Project: Madrona Crest Lot 9, 3605 86th Ave SE, Permit # 2306-185

I have reviewed the review correction notice from Kolke Consulting Group, Inc. and have the following responses to the Structural items. Please note that the numbers of my responses correspond to the numbers on the correction sheet.

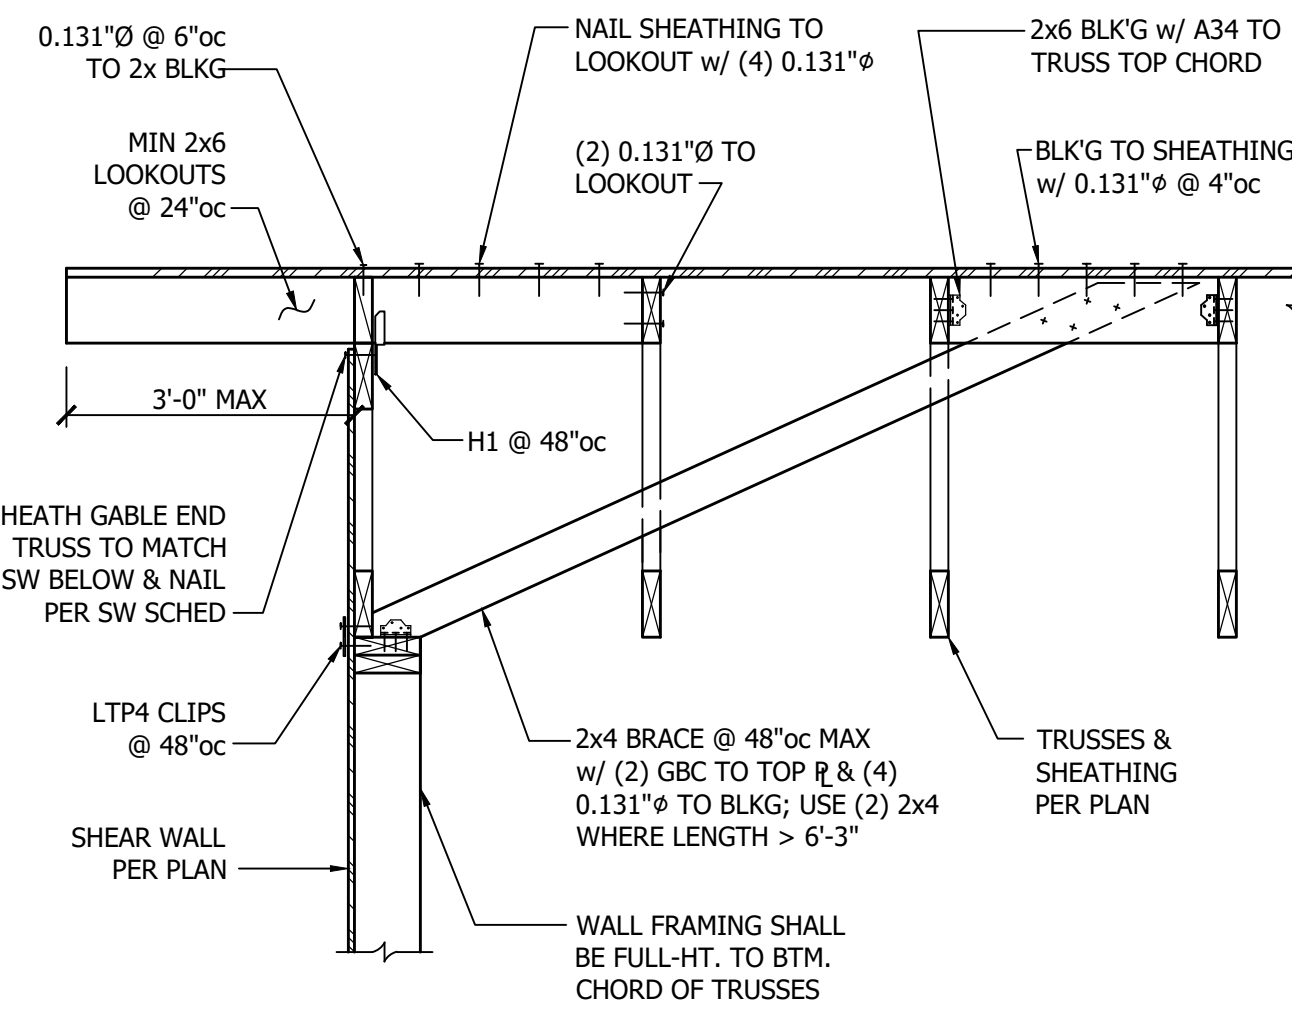
4. The typical gable-end conditions only provide shear flow connection from the roof sheathing through the H-clips before the wall sheathing is connected to the top chord of the gable end truss. Provide a connection sufficient for lateral load transfer at all shear wall conditions. Address the following:
 - a. Along Grid 5/6 you have noted the actual shear is 110 plf. At this location Details 2 & 3/S3.0 apply. These conditions only have H2.5A Clips at 24" on center. This only provides 55 plf. See also Grid 2.

b. Along Grid C, Detail 1/S3.0 applies which provides H1 Clips at 48" on center. These connections only provide 128 plf. Verify adequacy along Grid C

Response: The shear at details 2 & 3/S3.0 is directly transferred from the blocking to sheathing above the plate line. The H2.5 clips are only present to resist uplift forces.

Response: Detail 1/S3.0 has been revised to indicate H1 clips at 24"oc which will provide an allowable load of 220 plf.
